**M54 to M6 Link Road
TR010054**

**8.8 LIU(D) Draft Statement of Common
Ground with Nigel Simkin & Paul
Simkin**

STATEMENT OF COMMON GROUND

This Statement of Common Ground has been prepared and agreed by (1) Highways England Company Limited and (2) Nigel Simkin & Paul Simkin.

Plot Date: 20 January 2020 11:42:07
File Name: L:\PROJECTS\M05018038\M54-M6 LINKS\0 - TECHNICAL\8 - DIVISION\ENVIRONMENTAL MITIGATION\FIGURE 2.6 DRAFT ENVIRONMENTAL MASTERPLAN P10

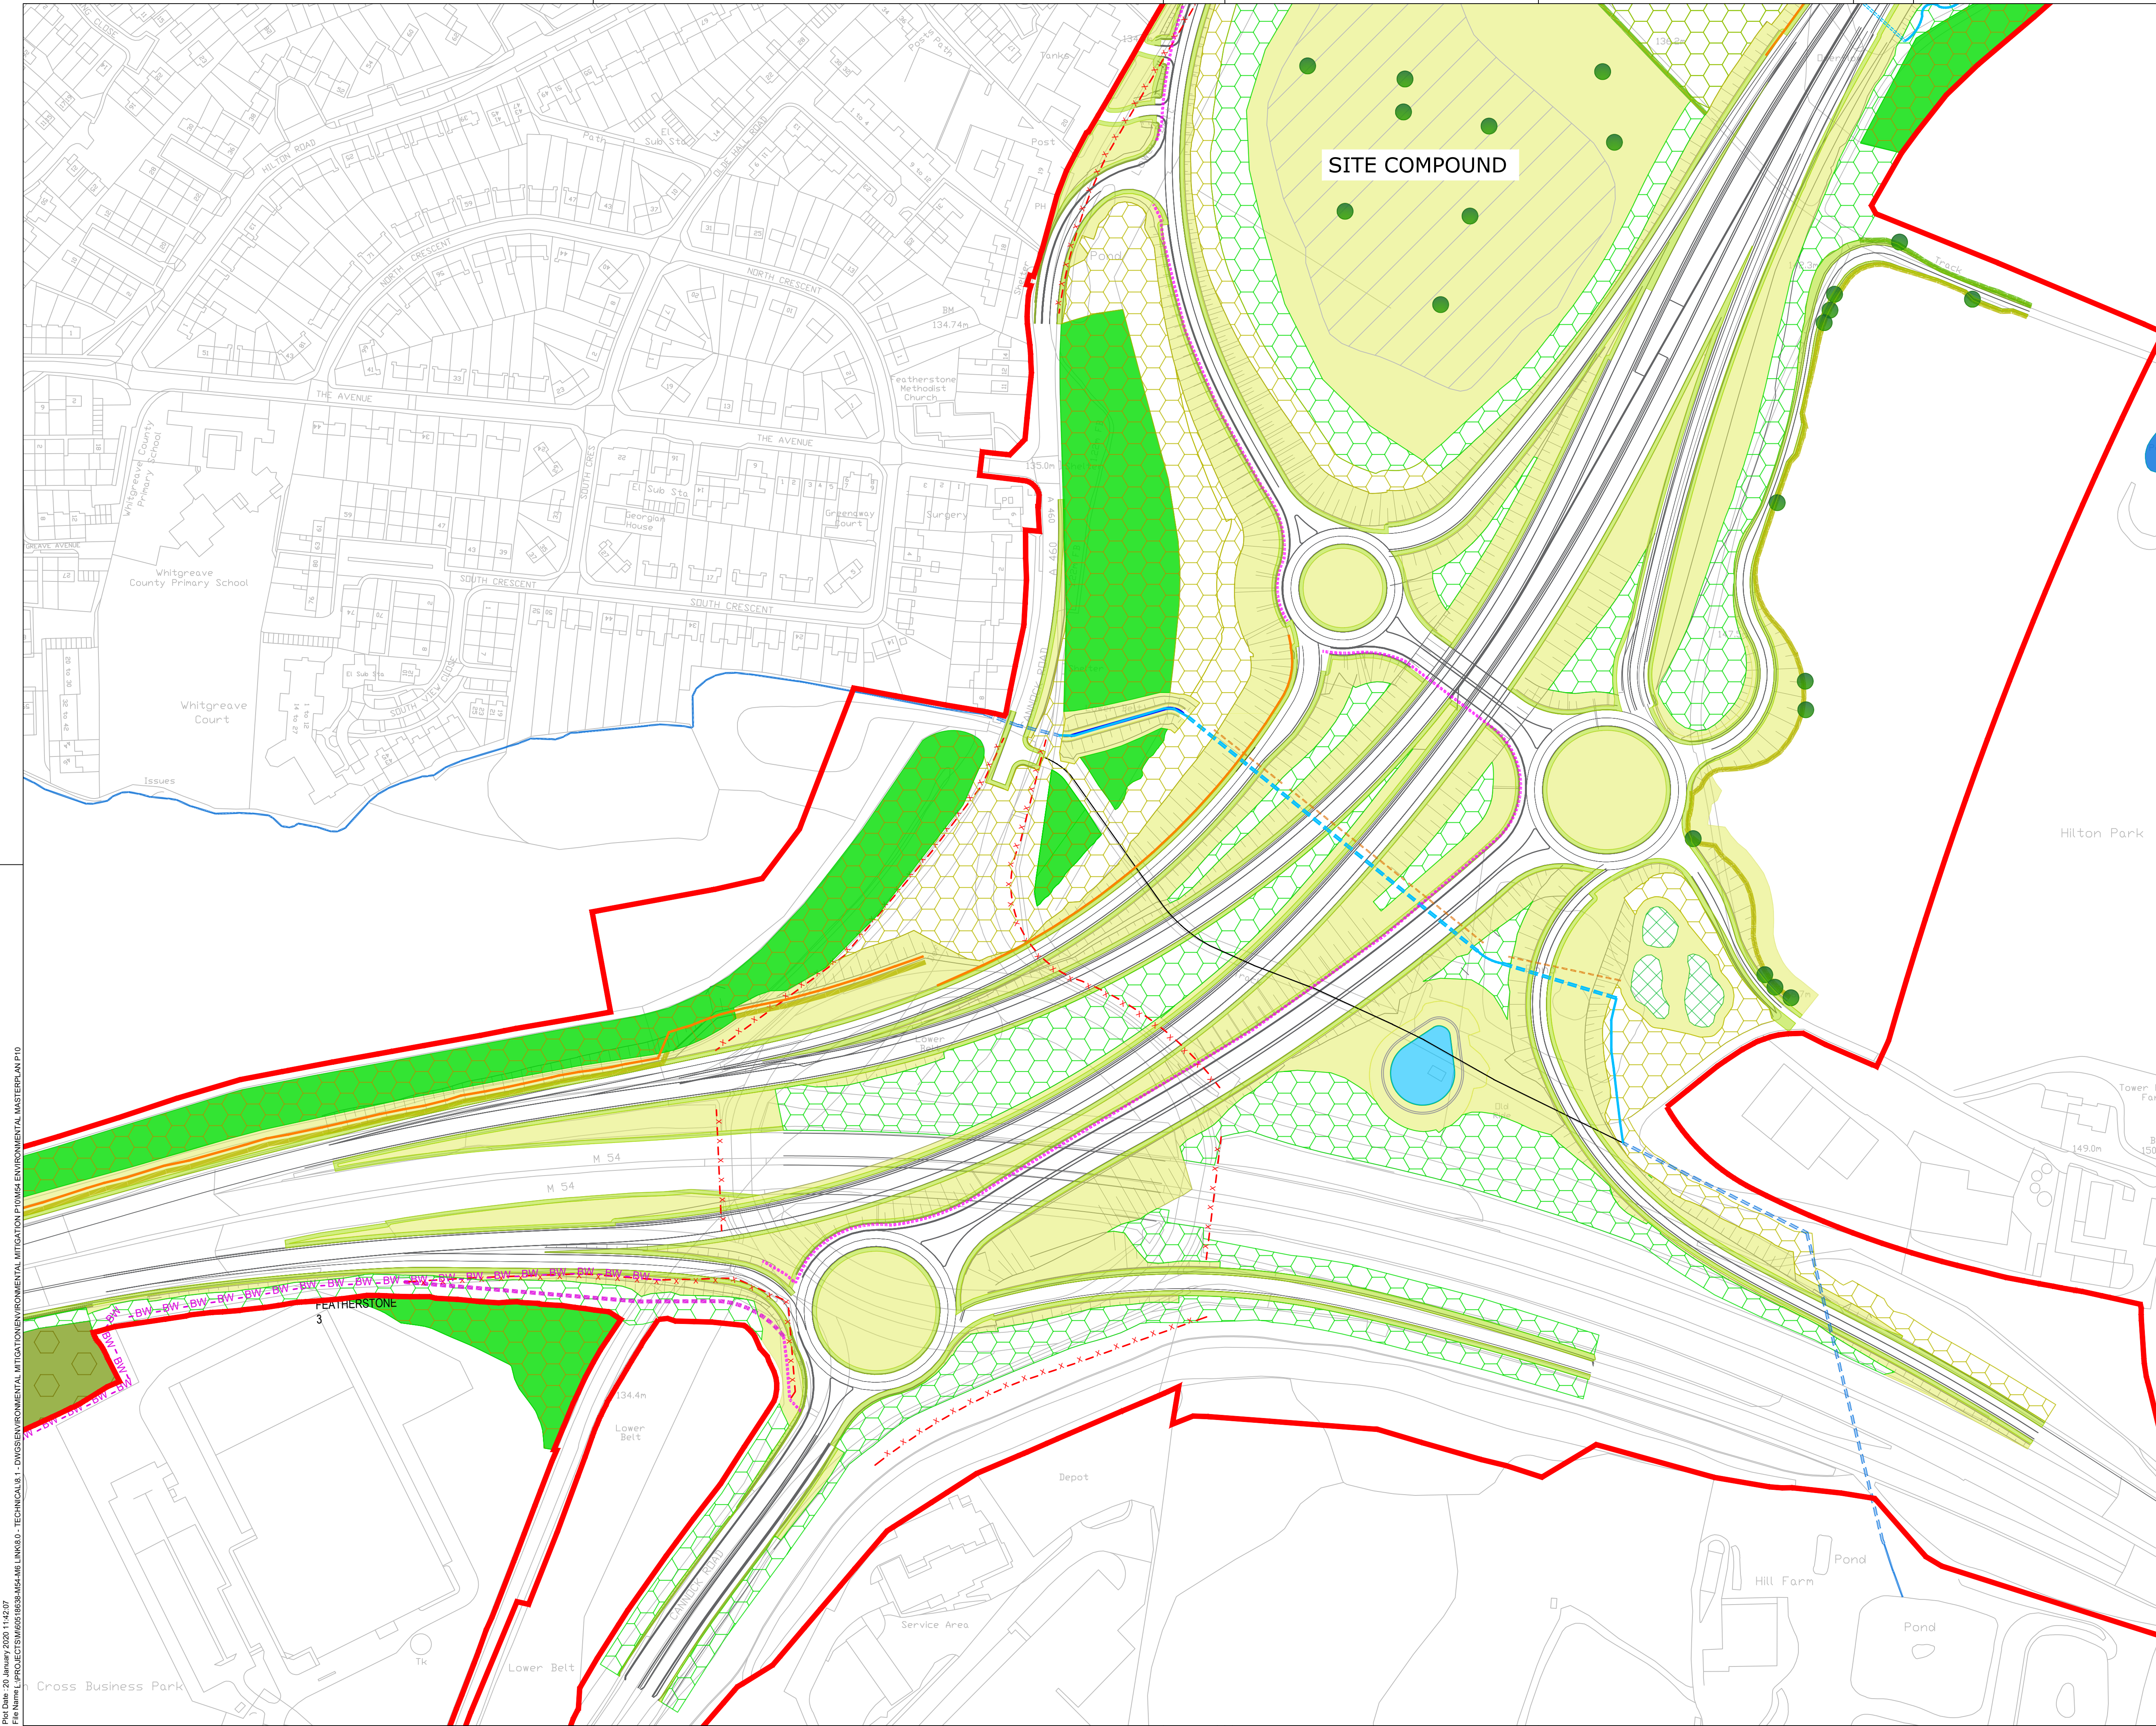
Subject	Document	Landowner Comment	Highways England Response	Status	Agreement likely ¹
	the changes to the DCO	welcomed however there appears to have been no reduction in the level of environmental mitigation planned on our client's landholding. In fact, the Environmental Masterplan indicates that there are to be additional hedgerows planted to the east of the link road.	<p>landowner's plot will reduce the mitigation on that plot.</p> <p>A mosaic of habitats has been included across the length of the Scheme but necessarily focused in selected locations to provide connectivity for protected species and designated sites. A reduction in habitat loss as a result of design changes and new survey data has enabled a reduction in the amount of land taken as mitigation from some landowners but not for all.</p> <p>Additional hedgerows have been proposed to provide boundary features for landscape integration and this also provides ecological enhancements on land that will be acquired for other purposes. Those areas are not being acquired for the sole purpose of hedgerow planting, but have been identified to mitigate visual and biodiversity impacts and around the Scheme.</p>

Subject	Document	Landowner Comment	Highways England Response	Status	Agreement likely ¹
		<p>With regards the suggestion there will be a small reduction in the area of ‘ancient woodland’ here, we have reviewed the previous Environmental Masterplan together with the revised Environmental Masterplan and can find no difference or change to the area of ancient woodland identified.</p> <p>Furthermore, we have previously raised that the area shown above has only recently been designated “ancient woodland” through the course of consultation meetings between Highways England and Natural England in relation to the scheme.</p> <p>Our clients dispute that the land is ancient woodland and has noted that the ancient woodland area identified has very young trees (i.e. not over 200 years old). They feel it is</p>	<p>There has been no reduction in the area of ancient woodland identified. Design change 3 (submitted on 9 October 2020) reduces the width of the embankment adjacent to the area of ancient woodland located within Brookfield Farm SBI, which reduces the loss of ancient woodland. The assessment reported in Chapter 8: Biodiversity of the ES [APP-047/6.1] identified 0.0015 ha of ancient woodland which would be lost during the construction of the Scheme, with a further 0.042 ha of ancient woodland located within 15 m of the construction works assumed to be lost due to the potential for root damage at this distance.</p> <p>The design change limits the loss of ancient woodland to 0.029 ha within 15 m of the construction works only. This level of detail is not shown on the draft Environmental Masterplan but is assessed within the Environmental Statement (updated chapter 8 submitted to the ExA on 09/10/20 [AS-083/6.1]). In addition, there is a loss</p>	Under discussion	Medium
